Chatswood Chase Shopping Centre Table of Response to Submissions

The table below summarises the responds to issues raised as part of the exhibition of the EAR. The table should be read in conjunction with correspondence from WCC dated 8 August 2007 provided in Appendix A.

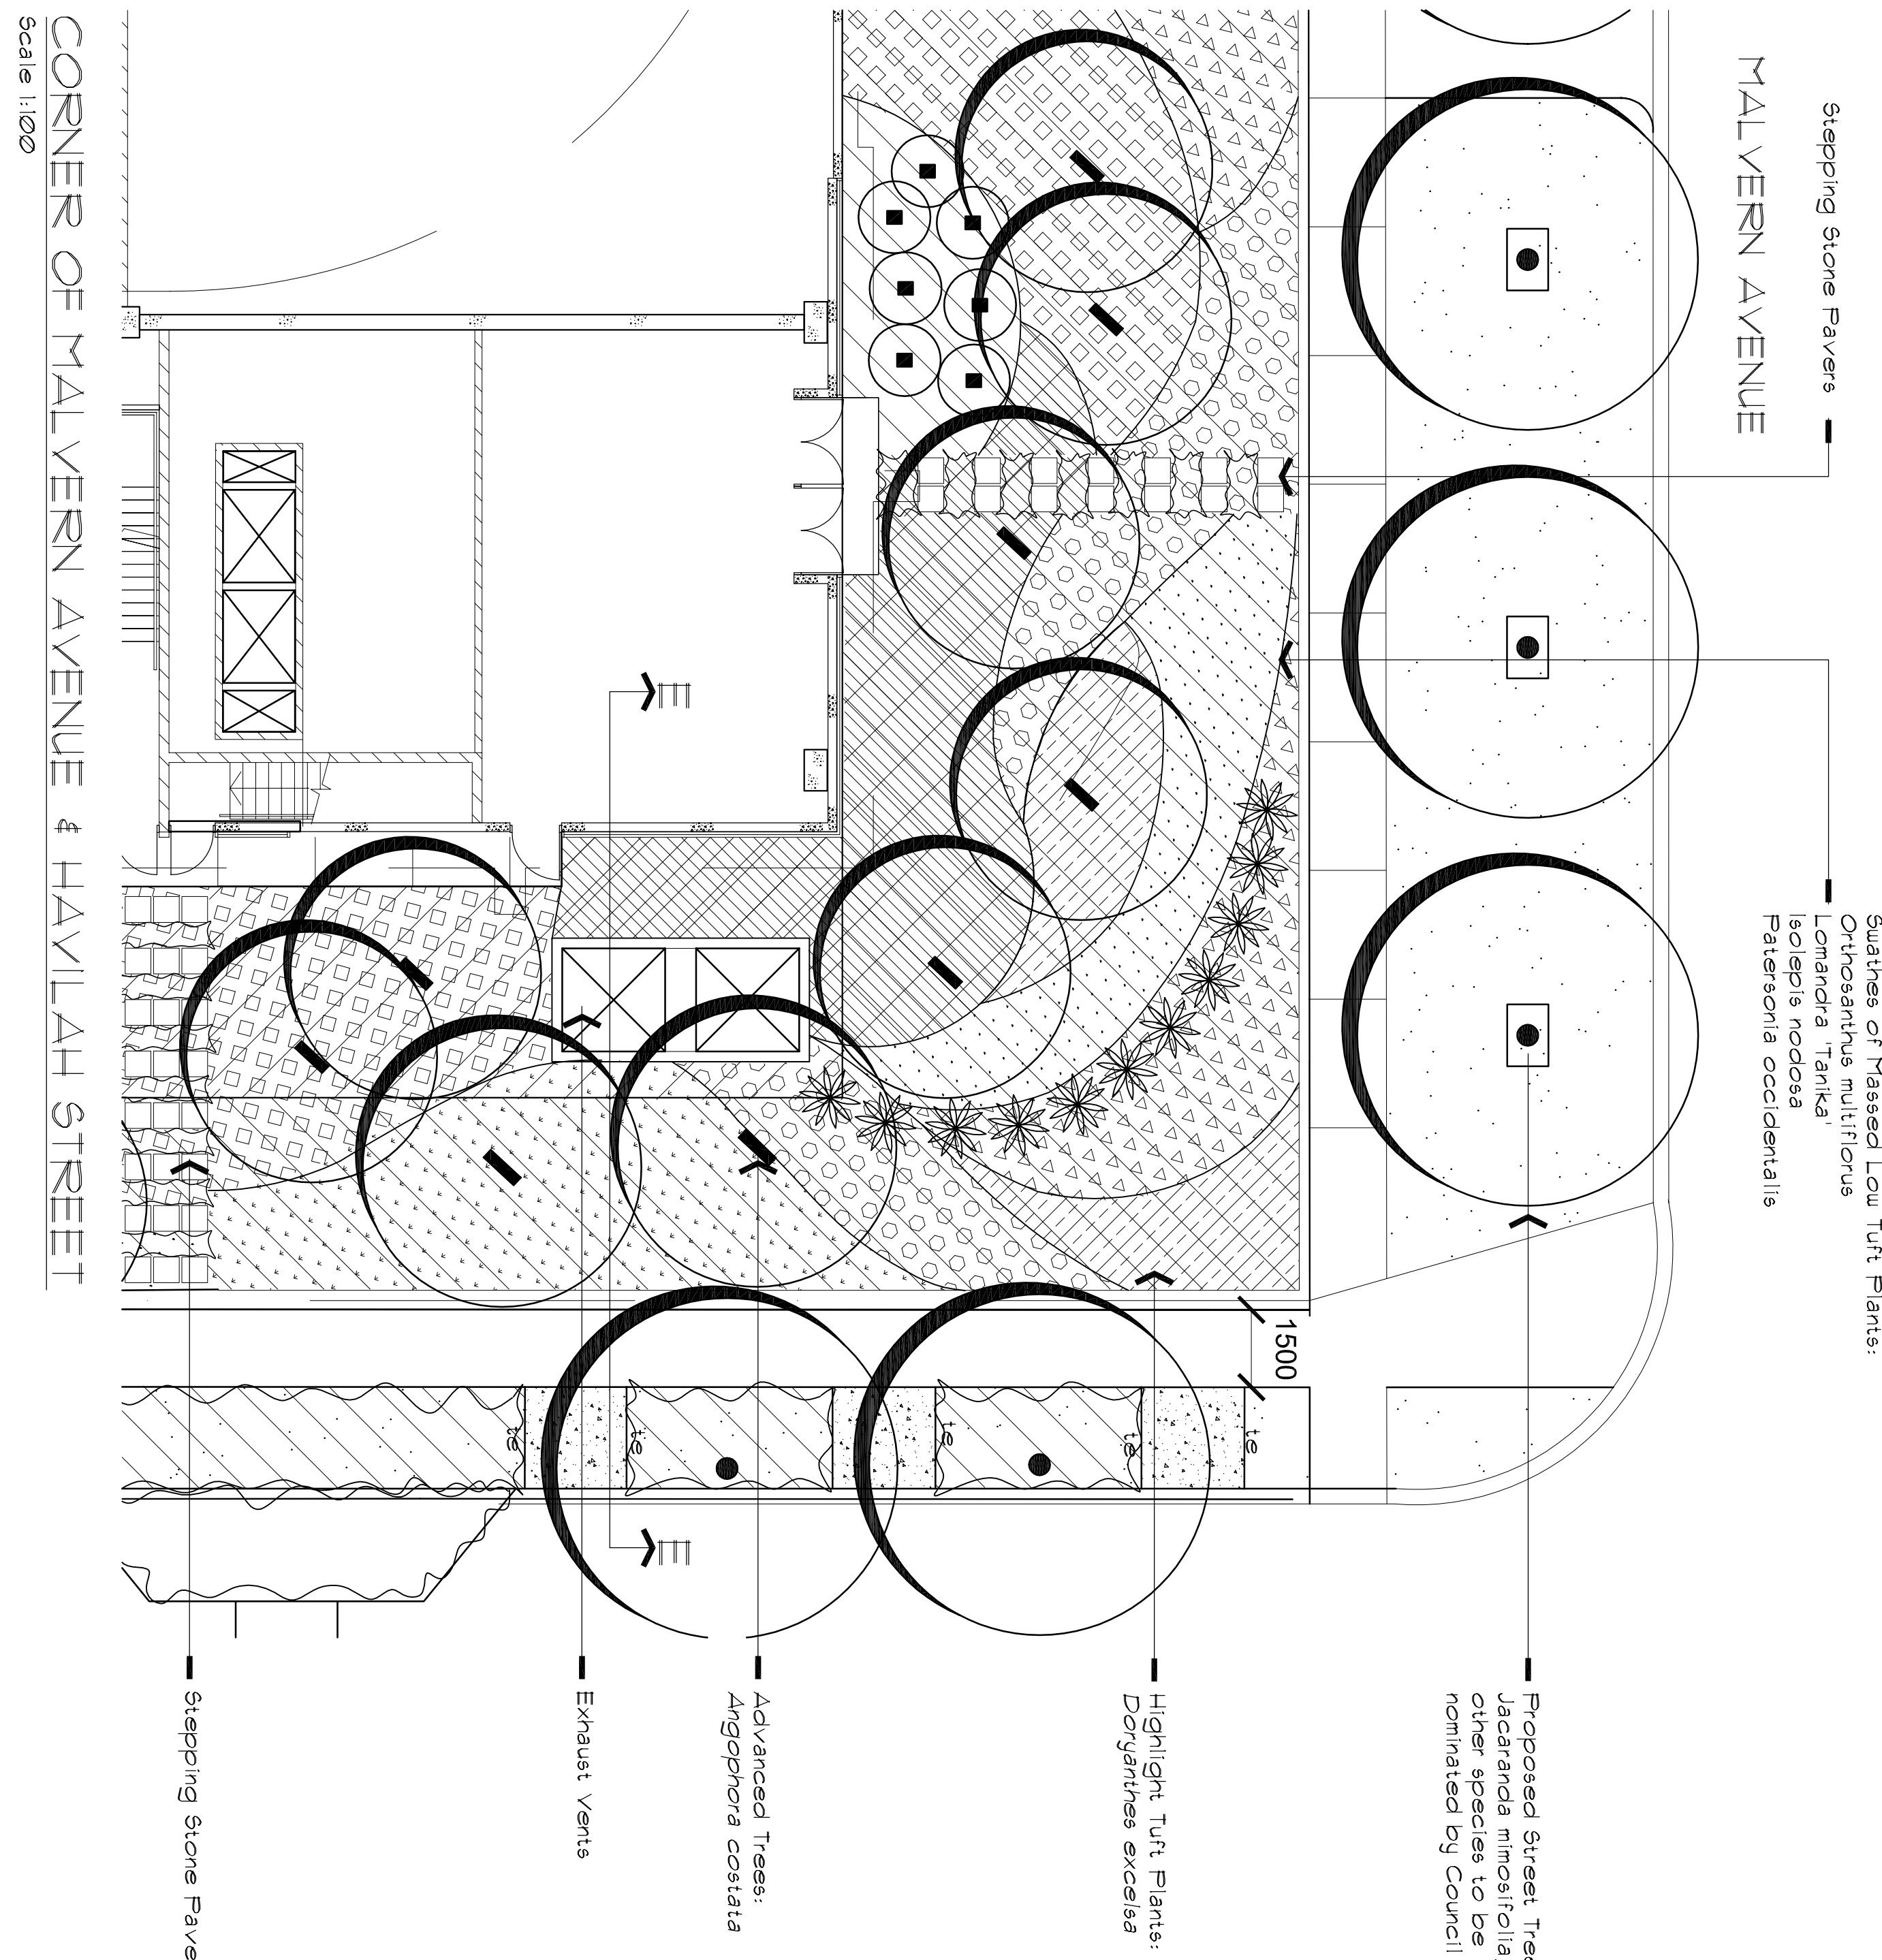
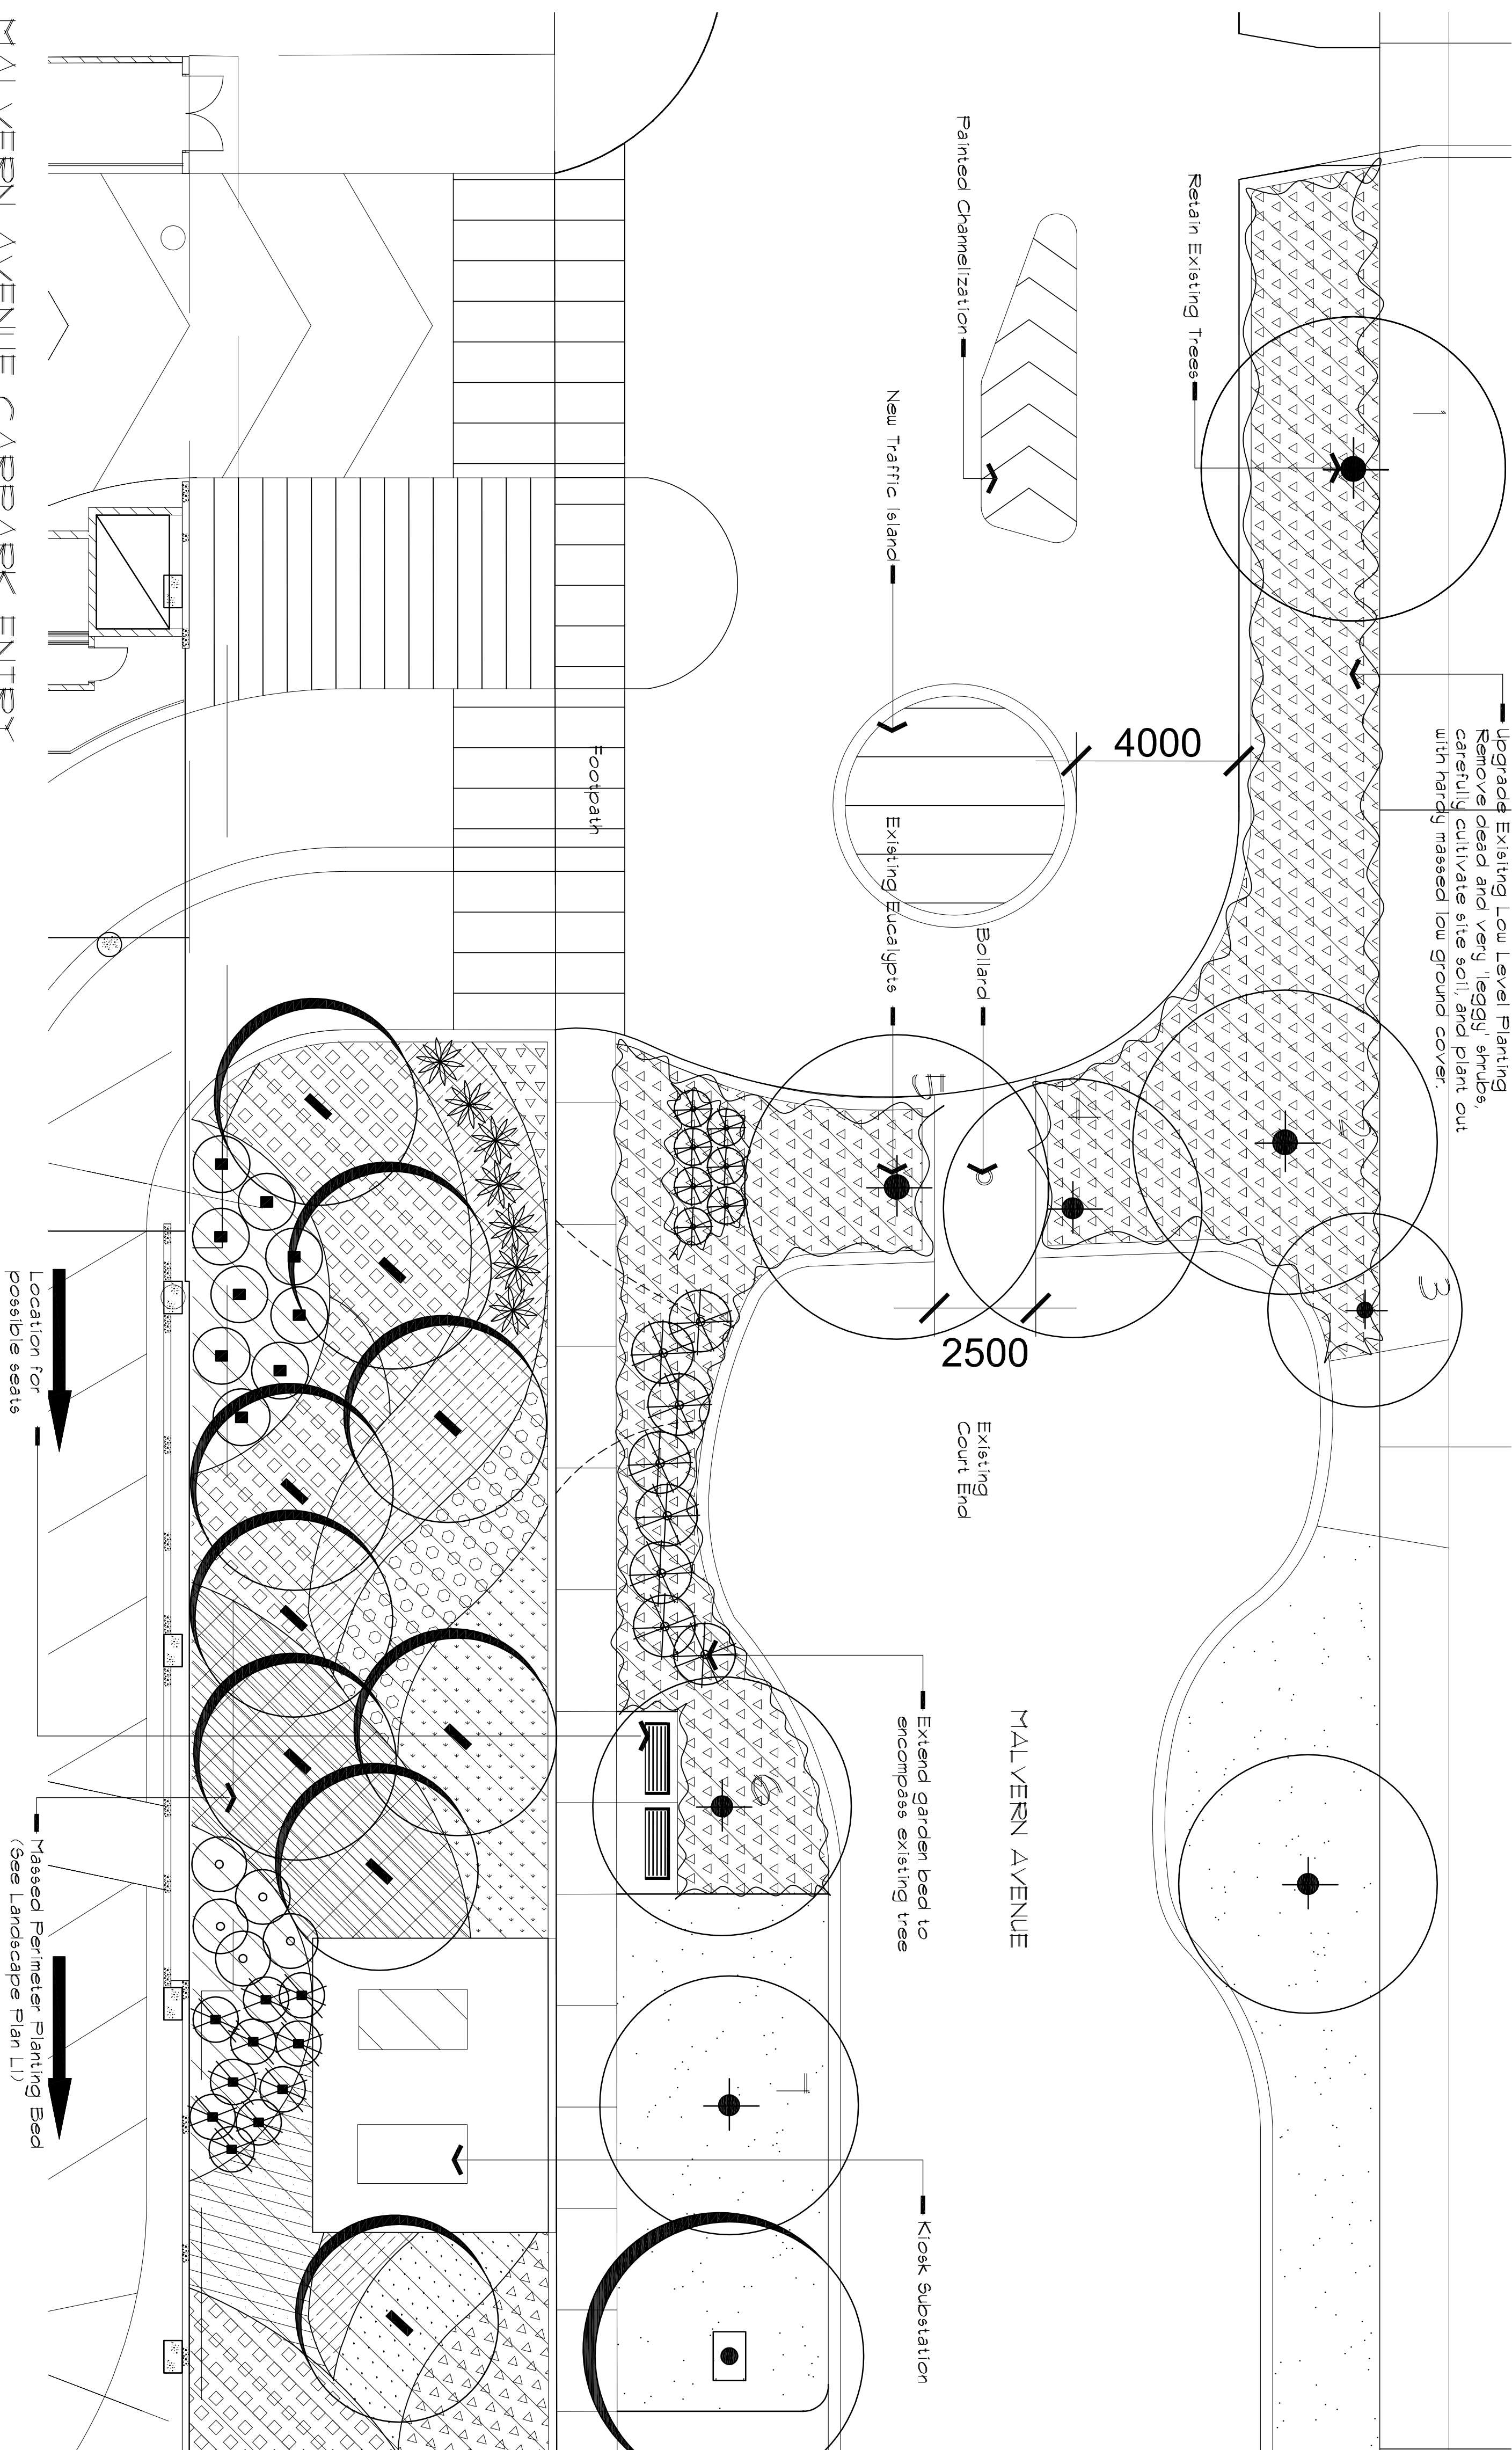
13	<p>At the public meeting, comment was made by your architect that it was expected that there was potential for three of the existing trees in the Havilah Street setback to the existing car park will be retained. Council's Landscape Section requires clarification on this point having regard to the extent of demolition and building works that may impact on the root system of the trees. The clarification needs to carefully consider the species, age and health of the trees noting that if damaged through the demolition/construction process, they may become a danger in the future for pedestrians in the vicinity.</p>	<p>The existing tree screen will be lost during construction. A new integrated landscape installation will be provided from 5-7 Havilah Street around to the boundary with 12-14 Malvern Avenue.</p> <p>Hedge planting and new street trees will be planted to Council requirements along Havilah Street as agreed with Council. Illustrated on updated Landscape Plans, Drawing Numbers 1461-LC1 and 1461-LC2.</p>

14a	<p>Various inconsistencies exist between the landscaped plan and the architectural plans, these require review and clarification. These include:</p>	Updated Landscape Plans provided, Drawing Numbers 1461-LC1 and 1461-LC2.
14b	<p>– Level changes and the need for retaining walls along the boundary with Havilah Street in the architectural plans that do not appear in the landscape plans. Council's expectation is that the interface is seamless with minimal level change and if a change in level is required it is not of a height that requires fencing.</p>	The detailed design to achieve Council's expectation will be addressed prior to issue of the CC for Landscaping.
14c	<p>– A paved pathway from Malvern Avenue enters that site to the building but its purpose is unknown.</p>	Stepping stone pavers have been provided where access is required to switchrooms.
